Historic England

**GEORGE HOTEL, ST GEORGE'S SQUARE, HUDDERSFIELD, WEST YORKSHIRE
HD1 1JA
Application Nos 2023/90112 & 2023/90024**

Thank you for your letters of 25 April 2023 regarding further information on the above applications for listed building consent and planning permission. On the basis of this information, we offer the following advice to assist your authority in determining the applications.

Proposed Site Section BB-1 Block A
1 : 200

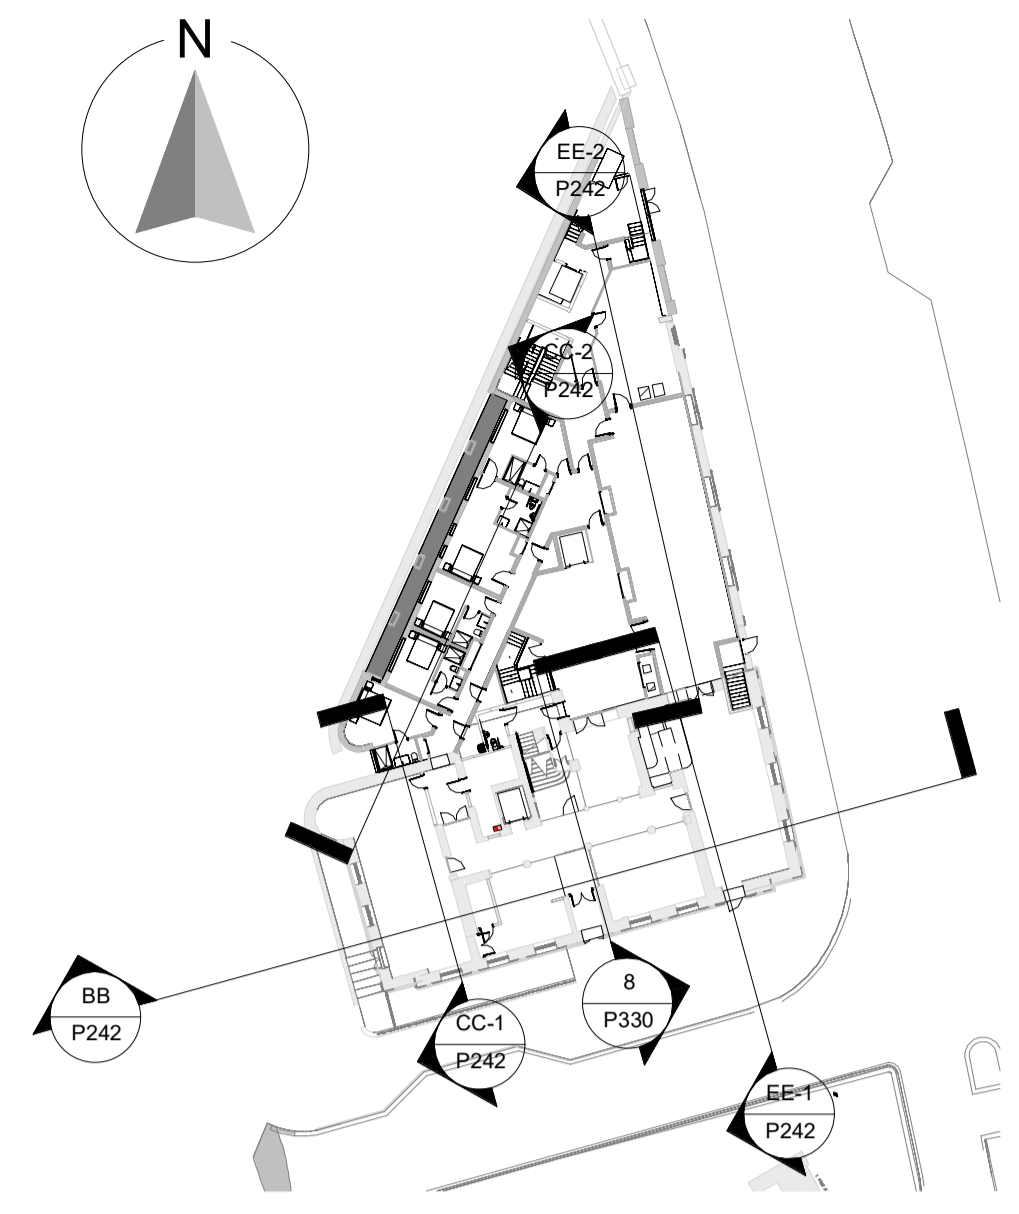
We do have concerns, however, about the proposals to remove the majority of the existing floor structures to facilitate the installation of acoustic and fire separation. Cumulatively this would be a considerable loss of historic fabric and decorative elements, particularly in the first-floor conference room which has a decorative plaster ceiling.

Following advice from our Structural Engineer we consider further focussed testing could reduce the impact on the existing floor structures. We would wish to see the ground floor structure and the second-floor structure above the first-floor conference room retained and recommend a design solution is explored for these areas.
